CITY OF ALBUQUERQUE

March 3, 2023

**RE: MDS - Montage Subdivision Unit 7 on Bobby Foster
Grading and Drainage Submittal for Preliminary Plat and Grading Permit
Grading Plan Engineer's Stamp Date: 12/12/2022
Drainage Report Engineer's Stamp Date: 1/20/2023
Hydrology File: R16D100A**

POND SUMMARY - REQUIRED VOLUMES FOR UNITS 3 AND 4				
POND	MAX WSE	REQ'D STORAGE VOLUME (AC-FT)	MAX DEPTH (FT)	MAX AVAILABLE VOLUME (AC-FT)
1 (Future)	NOT NEEDED	0.00	N/A	N/A
2A	5300.0	3.98	N/A	4.1
2B	5300.0	7.82	11.0	10.1
3	5300.0	8.54	11.0	10.1
4	5291.0	6.26	8.0	10.2

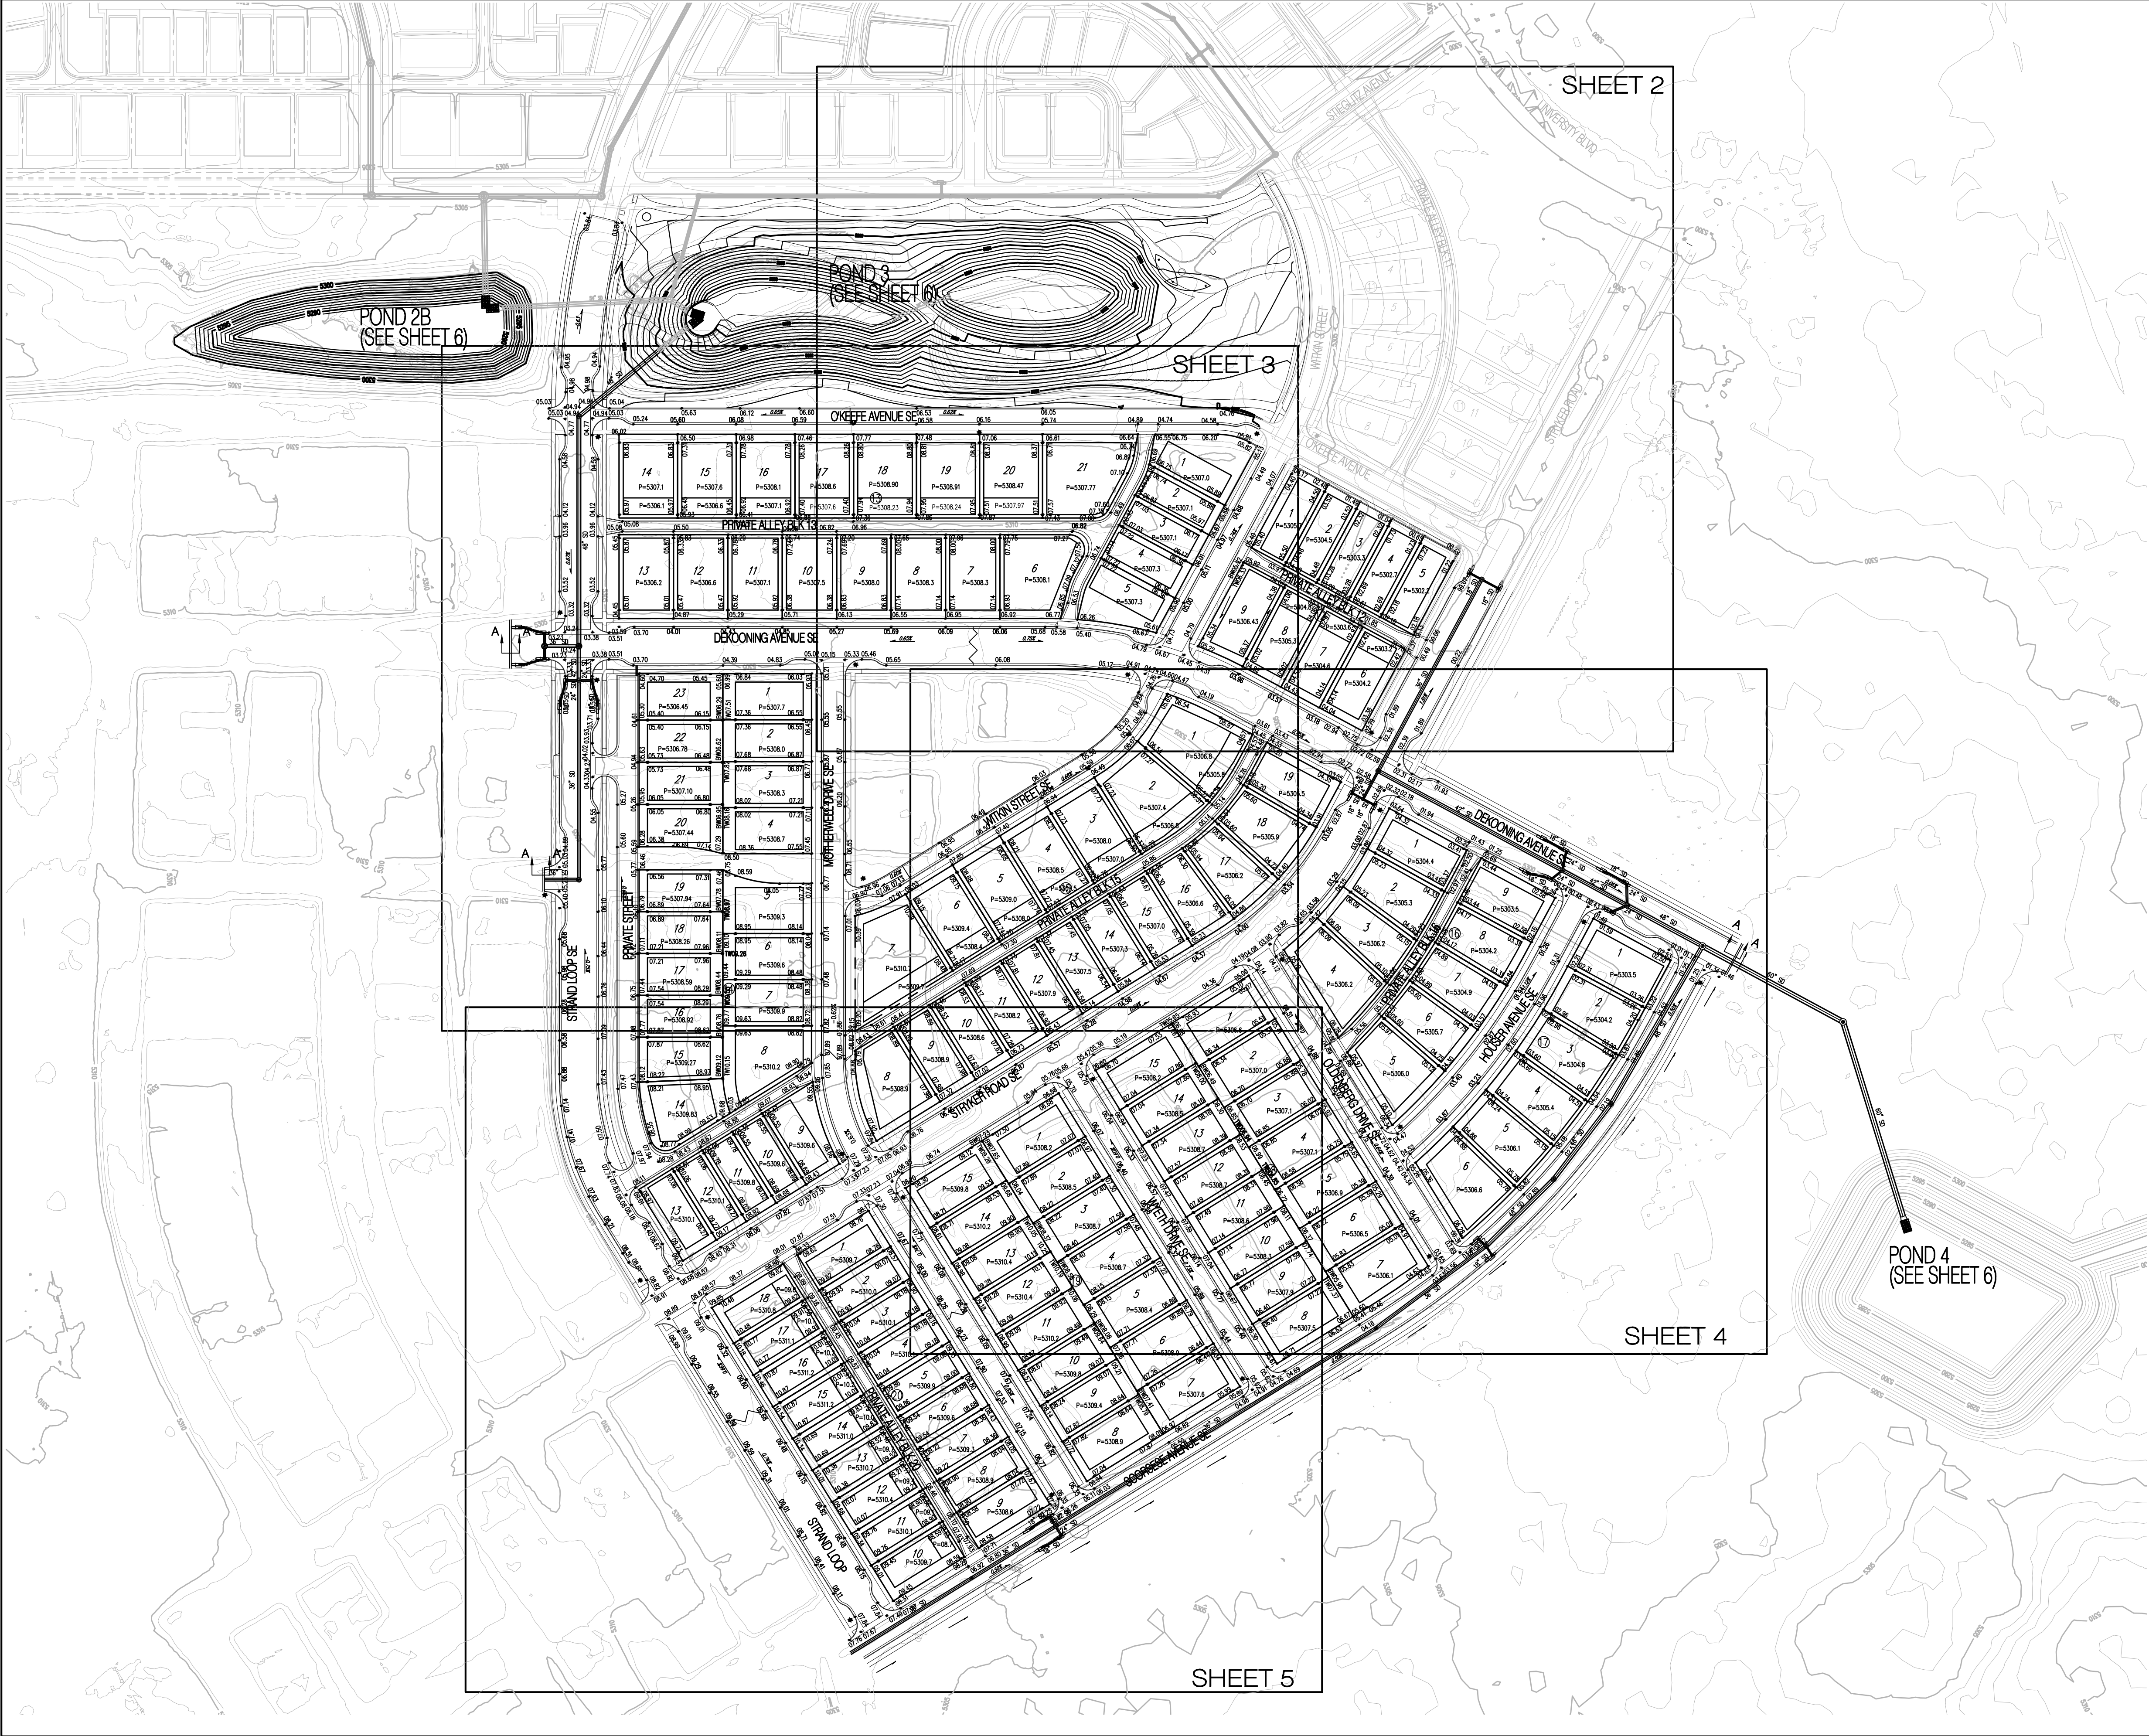
1. Neither this report nor the 2020 Bobby Foster Drainage Report has demonstrated adequate downstream capacity. Ponds 1 and 2A must be redesigned to retain the 100-year 10-day volume in accordance with the Montage Unit 3 & 4 Drainage Report with engineer's stamp date 1/18/2019. The 2020 Bobby Foster report and the 2011 Montage Units 1 & 2 Drainage Reports both undersized the ponds by designing them as detention ponds rather than retention ponds. (DH's previous comment dated 12/1/2022)

FIRMETTE

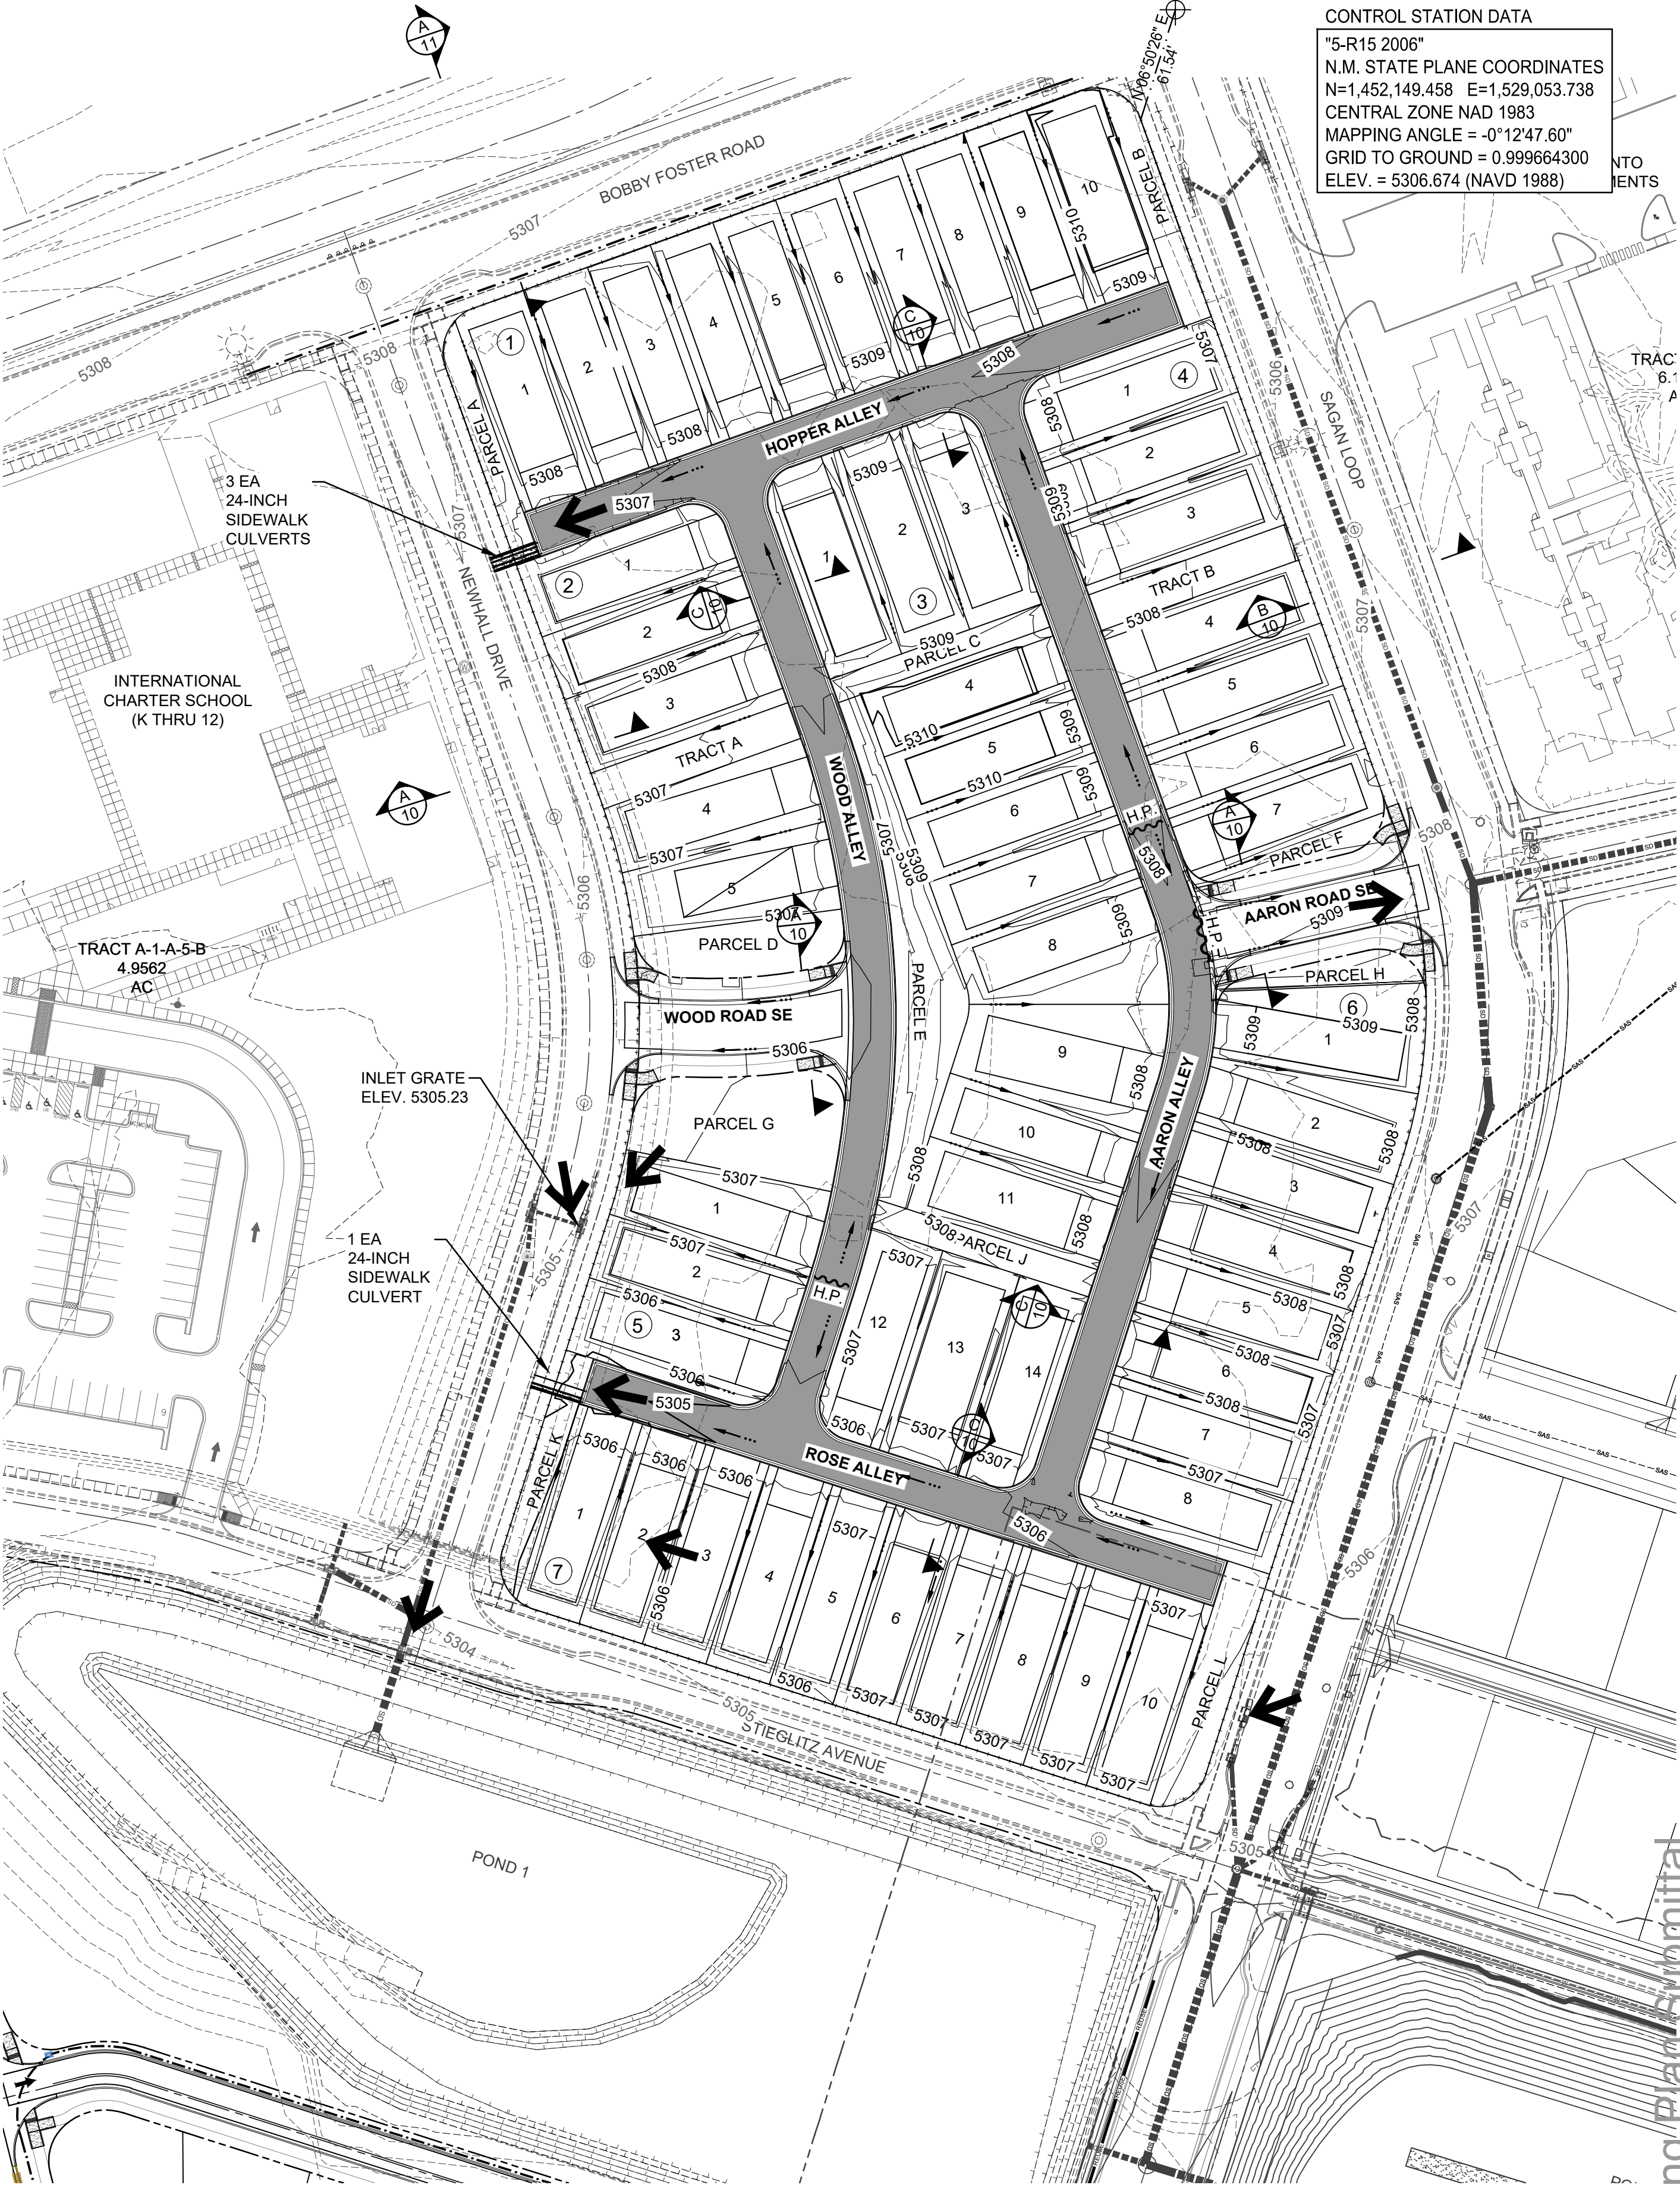
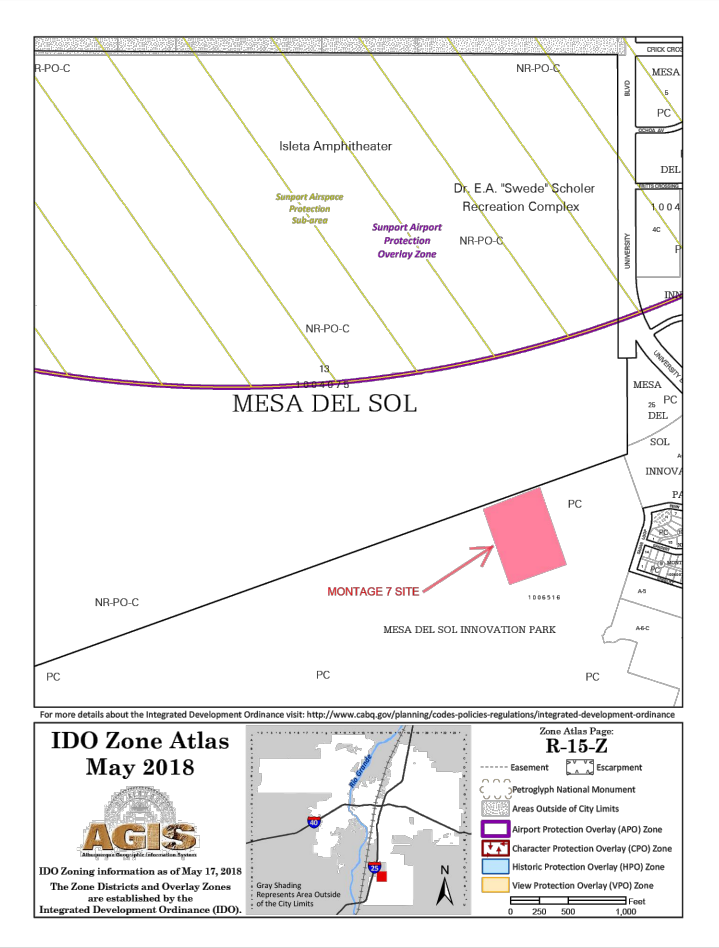
1. Please address Doug Hughes' comments dated 12/1/2022.
2. Add vicinity map and the FIRM Map number in a flood plain note with effective date on the plan.
3. Provide the Benchmark information (location, description and elevation) for the survey contour information provided.
4. Add a summary table showing the 100-yr, 10-day volume calculations and provided pond volume. Originally, pond 1 was anticipated to be constructed as a detention pond. It is now proposed as a retention pond. Does it need to be upsized?
5. Label "Pond 1" on the plan. Add drainage basins and alley names that were used in the drainage report on sheet 1.
6. Add "Existing SD" to the legend.
7. Define "design 1" and "design 2" on sheet 1.
